**Consultation Response from KC,  
Highways Development Management****2024/93177 Dixon Hall And Co Ltd, Grafton Street, Batley, WF17 6AR****Change of use from office building to residential apartments and associated alterations****Date Responded: 8-1-2025.****Responding Officer: Mark Berry.****Responding Ref: 15-4SE-14.**

Figure 1: Tracking Plan for HGV Vehicles

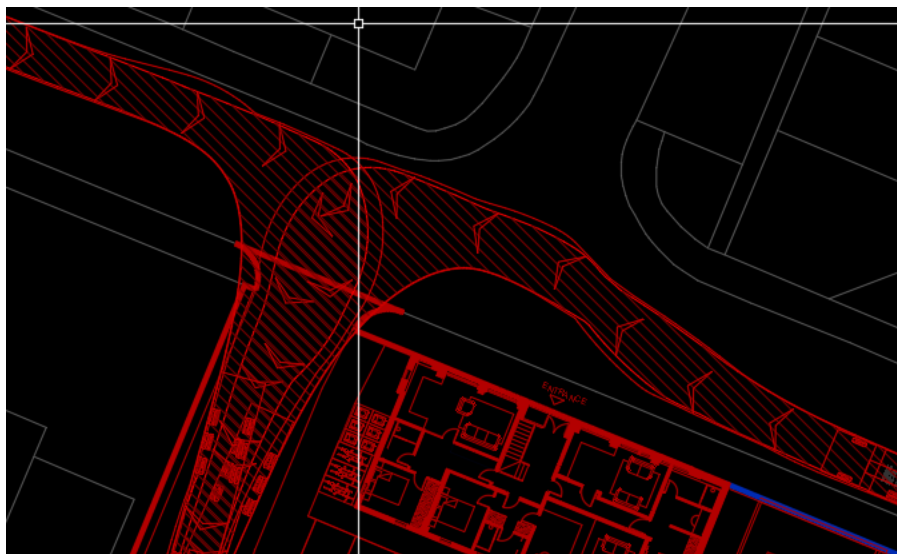
1, The swept paths shown within the Design and Access Statement only include a segment of the tracking drawing. Can the whole of the plan be provided which should show details of the size of the vehicle used. Also details of the visibility referred to be the Design and Access Statement should be provided.
